# CITY OF ALBUQUERQUE

October 30, 2017

**Re: Del Norte Baptist Church Site Improvements  
Erosion and Sediment Control Plan  
Engineer's Stamp Date -no stamp- (G18E010)**

EROSION AND SEDIMENT CONTROL PLAN

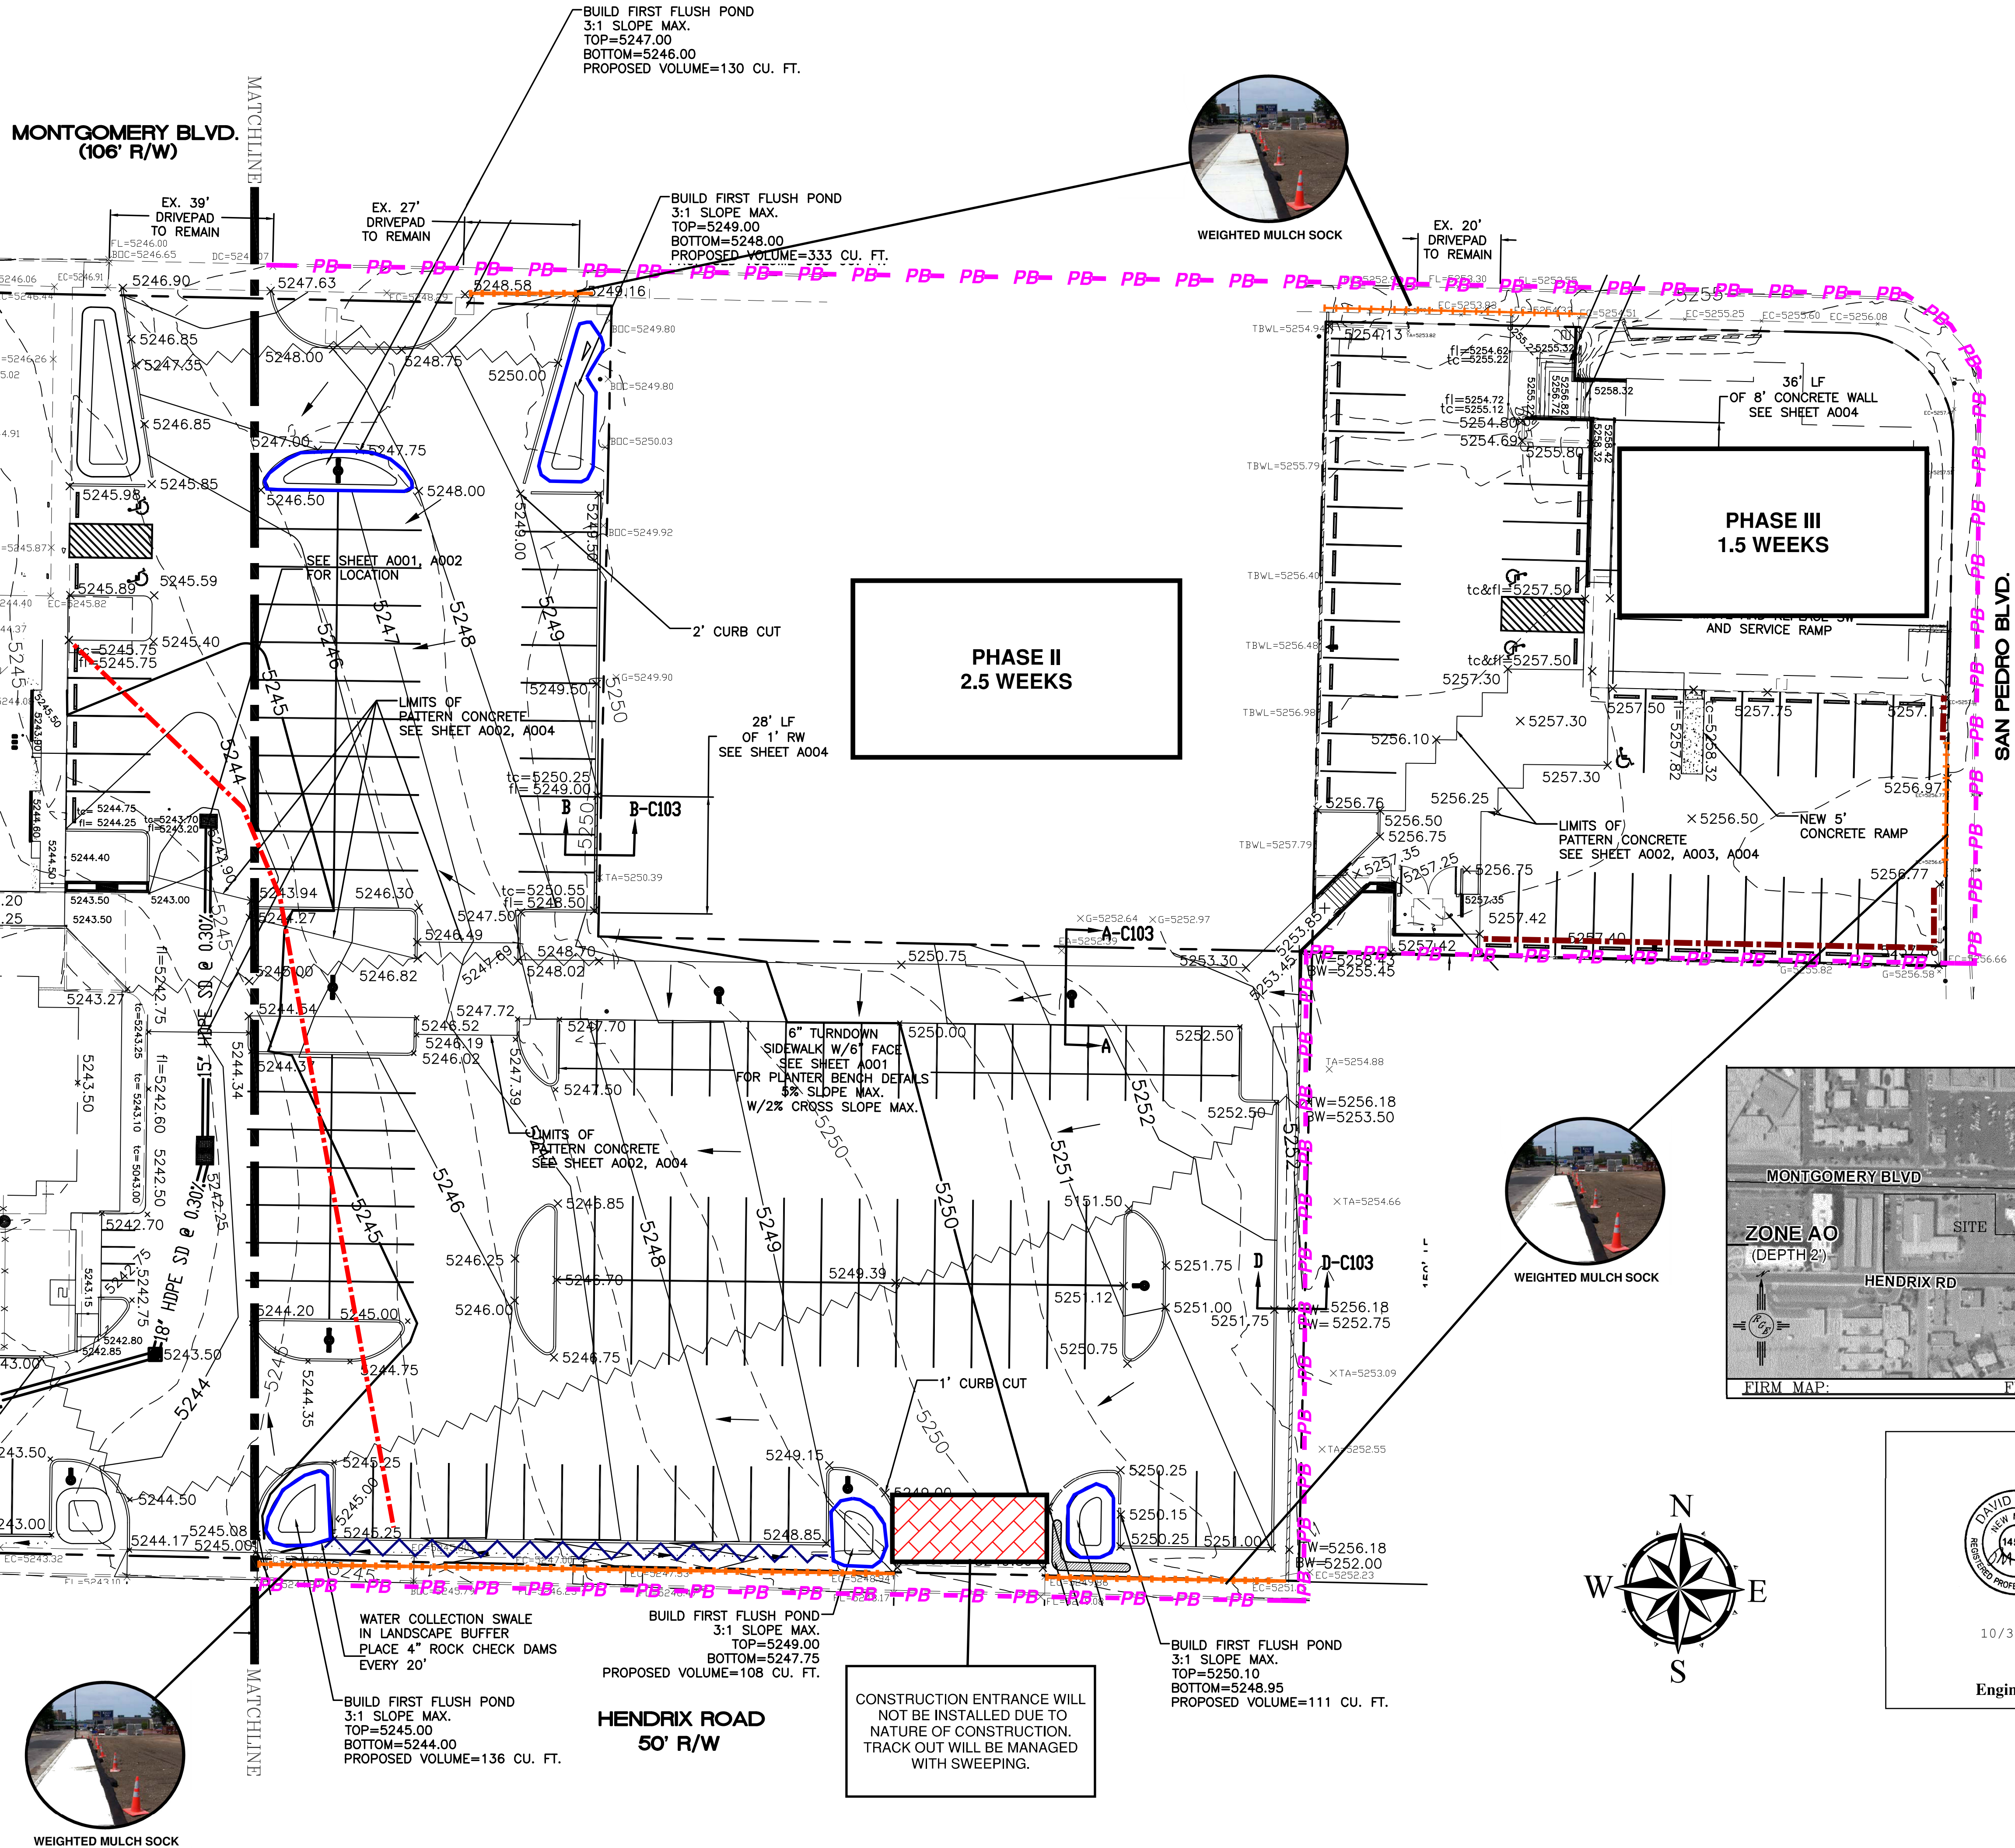
2. Provide the phase line(s) since the project will be completed in two halves or three thirds.

EROSION AND SEDIMENT CONTROL PLAN

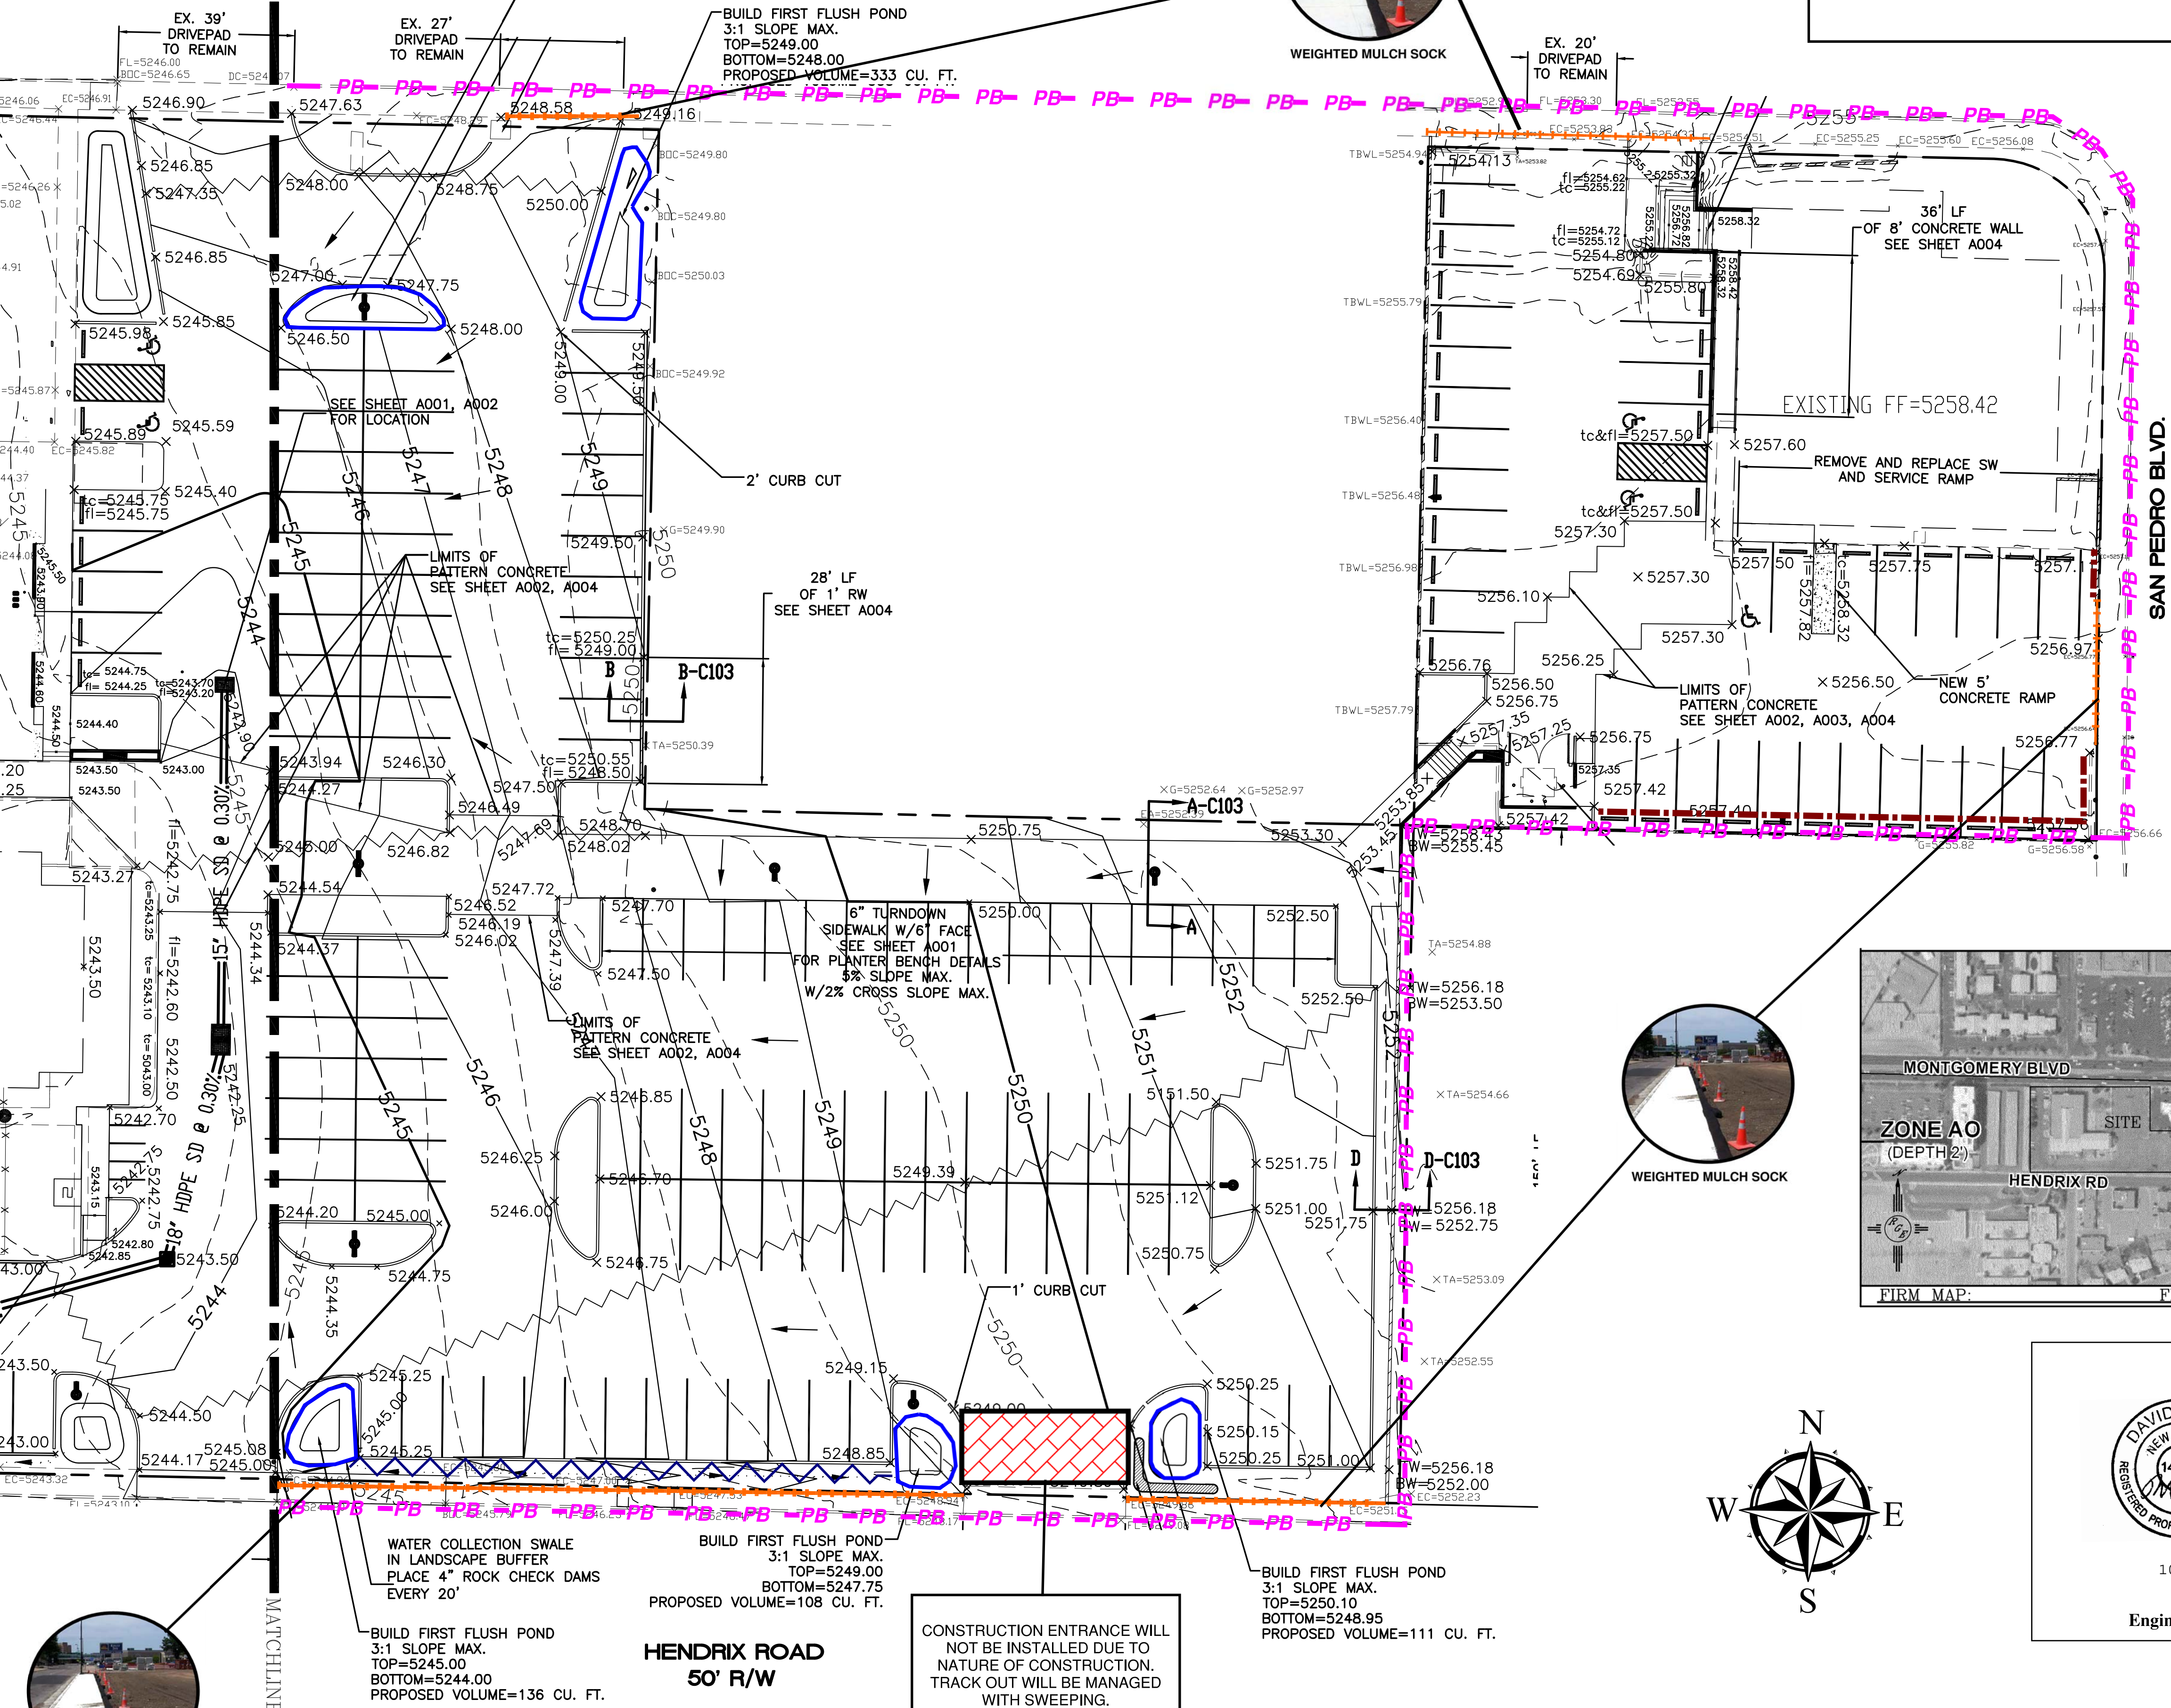
1. In general, a track-out pad is not required and track-out can be managed by sweeping/removal from street if a site is within 2 weeks of paving. It appears the small area along San Pedro may meet this criteria as only flatwork is proposed.

a. In the next section to the west, it appears that medians and lighting are proposed. Seems this work will take more than 2 weeks, therefore a track-out pad should be proposed.

b. The most work appears to occur in the western third of the site; storm drain, medians and lighting. A track-out pad should be proposed to keep construction vehicles off the new pavement and sediment out of the street.

3. A sediment BMP should be used along the downhill edge when the uphill phase is under construction to prevent sediment from entering the downhill portion.

4. The paper plan submitted to stormwater quality was printed in black and white. This makes it difficult to read when colors are used in the legend.

5. The paper plan was not sealed or signed by a NM PE.
